East Anglia One North (EA1N) and East Anglia Two (EA2) Offshore Wind Farms

**Planning Inspectorate Reference: EA1N – EN010077 &
EA2 – EN010078**

Deadline 5 - 3 February 2021

**East Suffolk Council's Response to Additional
Information Submitted by Applicants at Deadline 4**

Figure: 10g
CHVP5: PROW at Woodside Farm

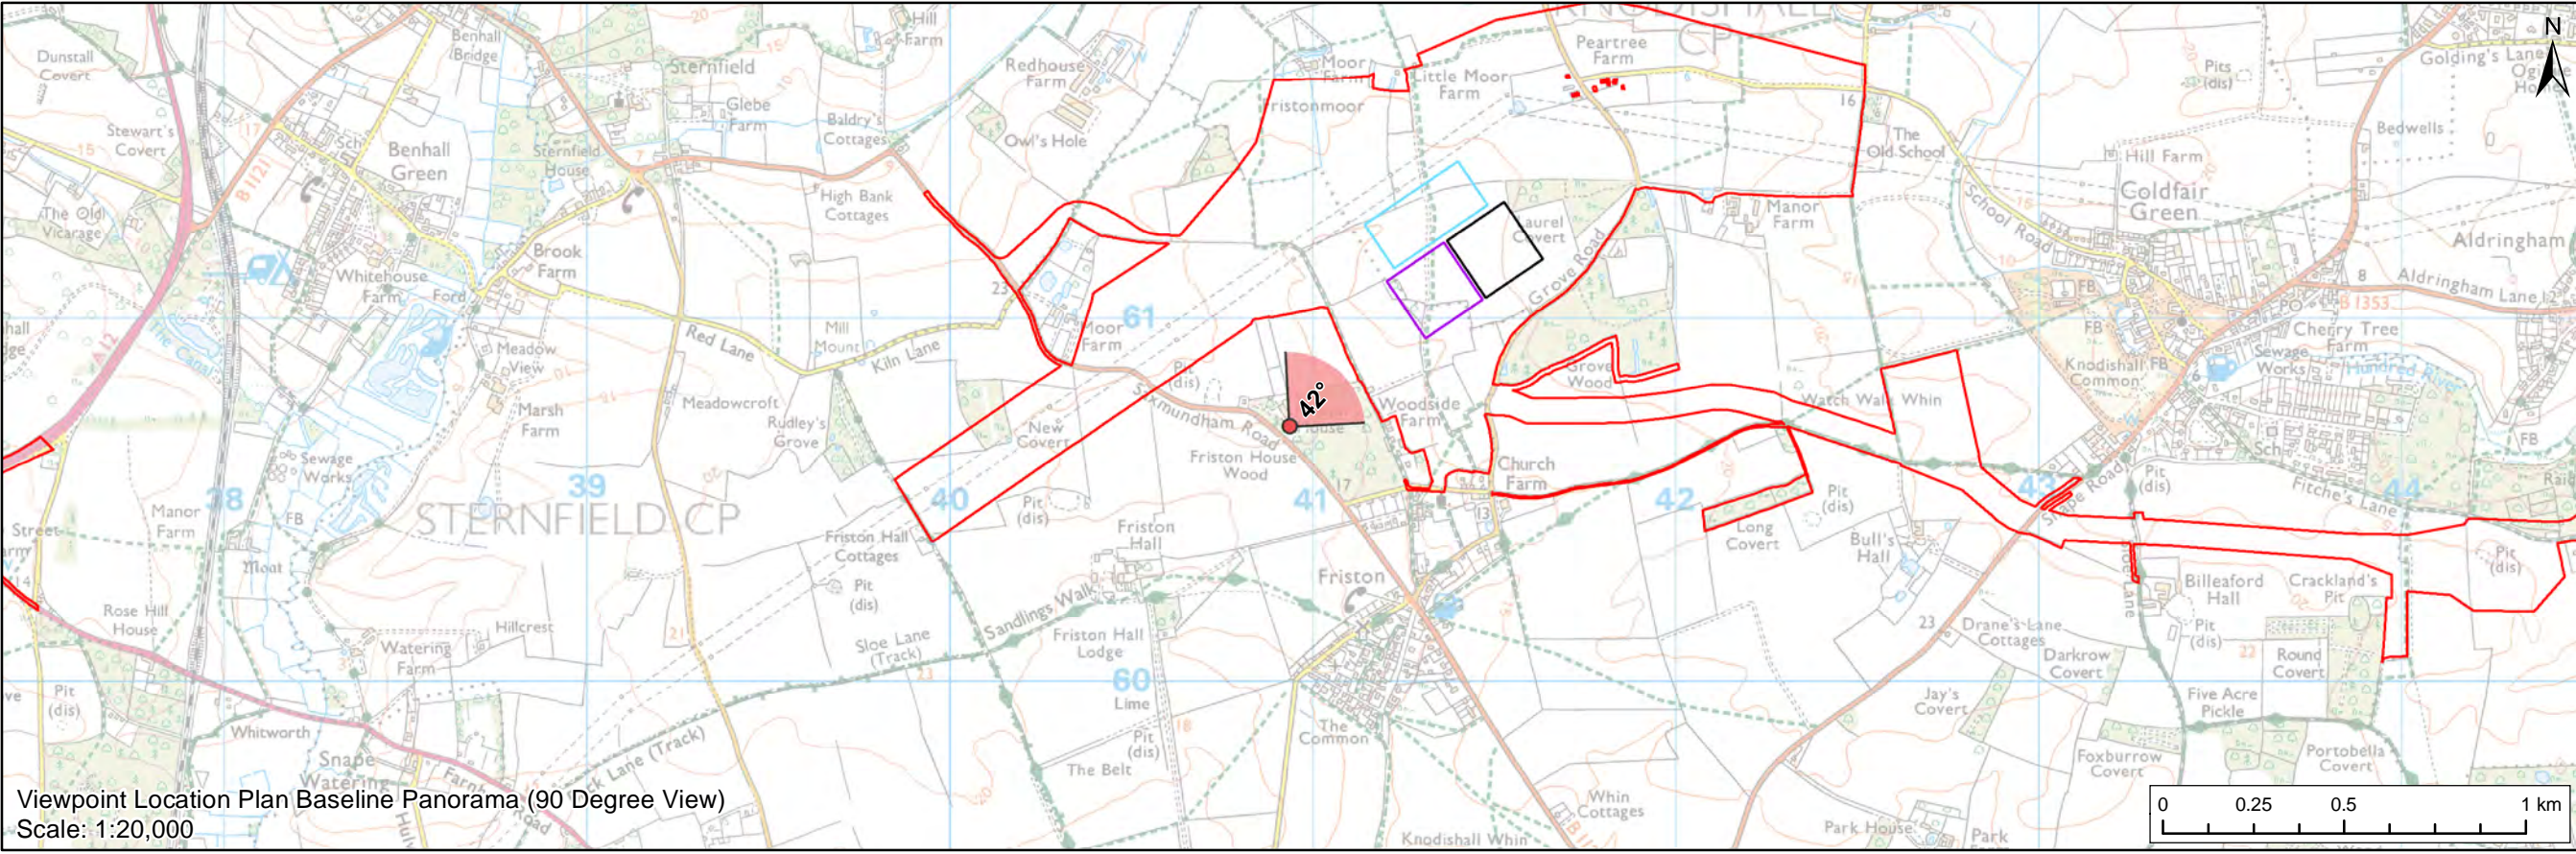
2.4 Woodside Farm		As stated in ESC’s at Deadline 4 (REP4-059), it is difficult to assess the remaining impact on the setting of Woodside Farm due to the limitations of the viewpoint. The reduction in scale means that the visual impact of the western substation would be reduced, however based on the other updated visualisations, it is likely that the top of the substations would still be visible above the treeline at 15 years, and that the massive scale of the substations would still be notable. Additionally, as noted previously, the proposed vegetation would still be a barrier in itself, which detracts from the open agricultural setting of the listed buildings.

<p>The magnitude of adverse impact would still be medium, giving rise to an effect of moderate significance.</p>
<p>2.5 Church of St Mary</p>		<p>In the updated visualisation of LVIA Viewpoint 2 (REP4-033) there is a visible reduction in the scale of the infrastructure for the Western Substation. LVIA Viewpoint 9 (REP4-039) shows the tops of the substation infrastructure above the treetops in the backdrop of the church, although lower than in the previous visualisation. There has therefore been a positive change in the visual impact of the development.</p> <p>Notwithstanding this, visual impact is only one of the factors leading to harm to the significance of the church; others being the interruption of important views and of the relationship between the church and the historic properties to the north and the reduction of the open rural character of its wider setting. The reduction in harmful visual impact would not be sufficient to lower the level of harm which has been previously identified.</p> <p>The magnitude of adverse impact would still be medium, giving rise to an effect of major significance.</p>

Figure: 12g
CHVP7: Friston House (b)

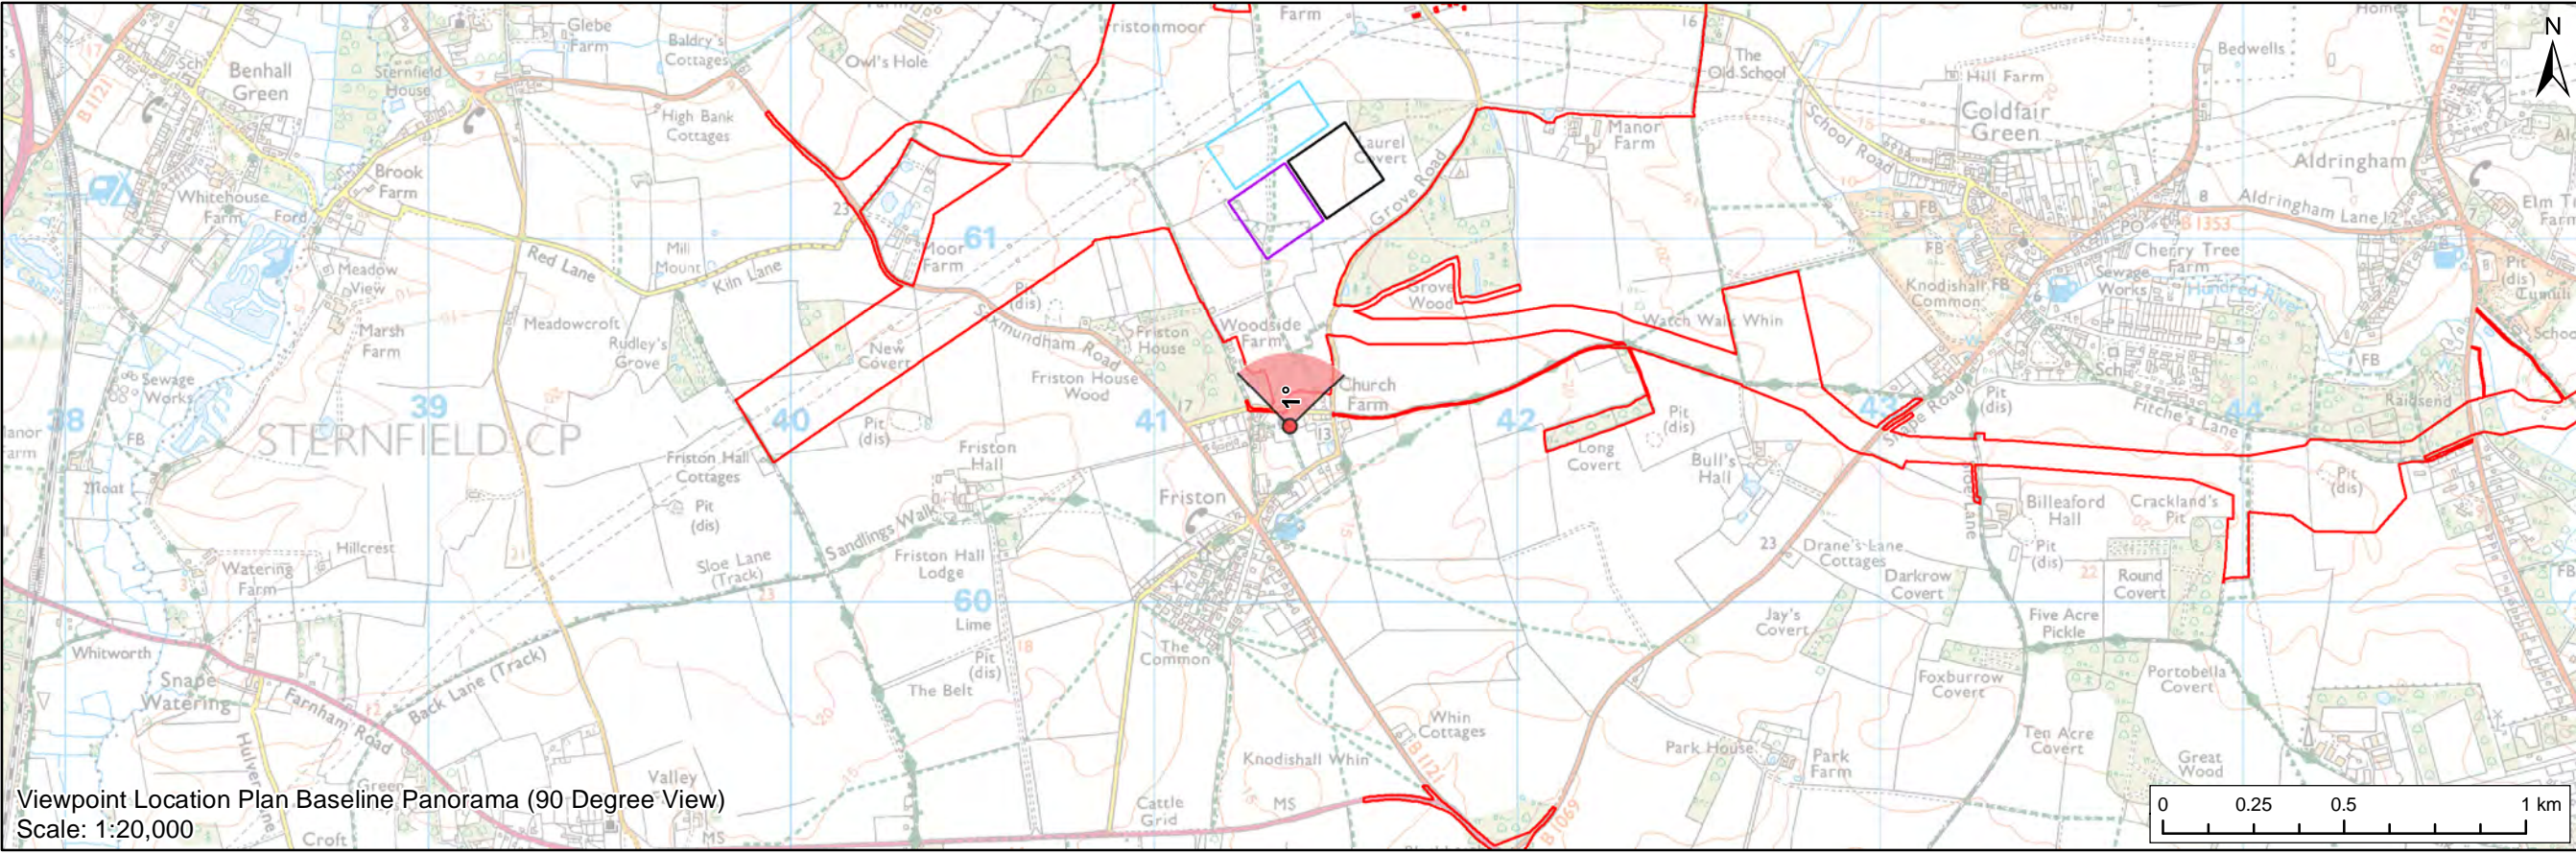
1.4 Additional Planting at National Grid Substation		The additional planting to the north of the National Grid substation is noted and provides more effective screening of the eastern section of the developments. Further consideration of the effect of this planting is provided in this table below in connection with ESC’s comments on the Heritage Assessment Addendum (REP4-006) and discussion of Little Moor Farm and CHVP3 (REP-008) in the table on page 30 onwards.
